Application by RiverOak Strategic Partners to upgrade and reopen Manston Airport

The Examining Authority's second written questions and requests for information (ExQ1)

Please find below Thanet District Council's response to the second written questions of the Examining Authority.

Northern Grass (RPS-MSE-XX-DR-C-2089)

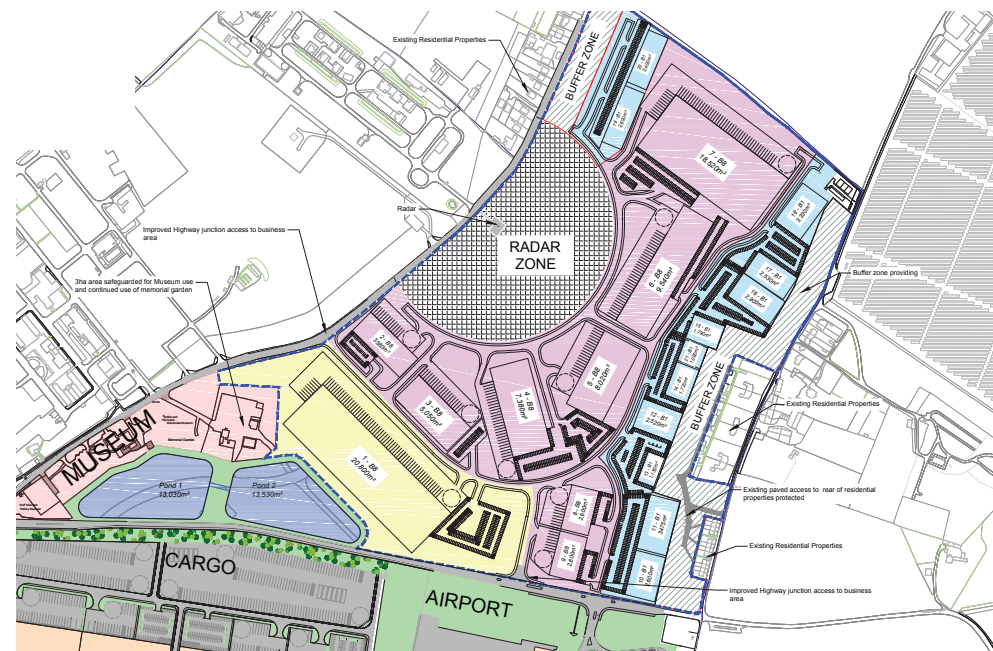
Part of the alternative route is within the order limits, however it has not been demonstrated how this affects the masterplan for the northern grass area, with the north-west corner of the site being affected by the route including the radar area and indicative location of buildings. This means that the alternative route could not be provided if the development is built as proposed, with the route not safeguarded.
